## PA23031 - COMMENT RESPONSES

Re: # PA23031 - Marysville Riverwalk — Response to Technical Review 1

Below are responses to the comments on Technical Review 1 (3/4/24). Comments are italicized, followed by our response in standard text.

GR1

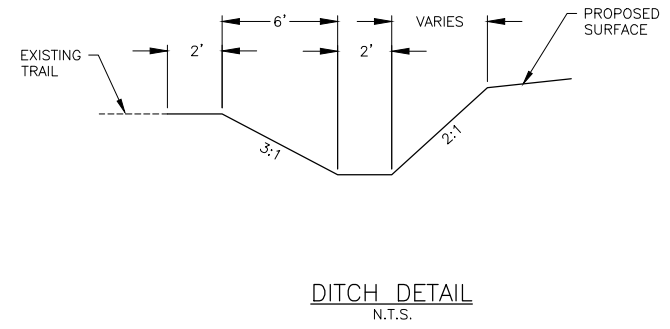
2. *The grading plans (E031) shall be amended so that **no** temporary stockpiling occurs on the lagoon fillpad (Stockpile A), as the PW Department utilizes this space for operational purposes. Until the PW Department has been relocated all stockpiling shall be placed on the Interfor property (60 State Avenue).*

Grading plans have been revised.

*41. Am I seeing that 46,950 cy of fill is to be stockpiled within the 70ft Slough setback? Isn't that area full of existing native vegetation?*

The stockpile plan will be checked and revised to ensure no soil encroachment into the 70-foot setback. A revised grading plan was submitted to the permit file with these responses.
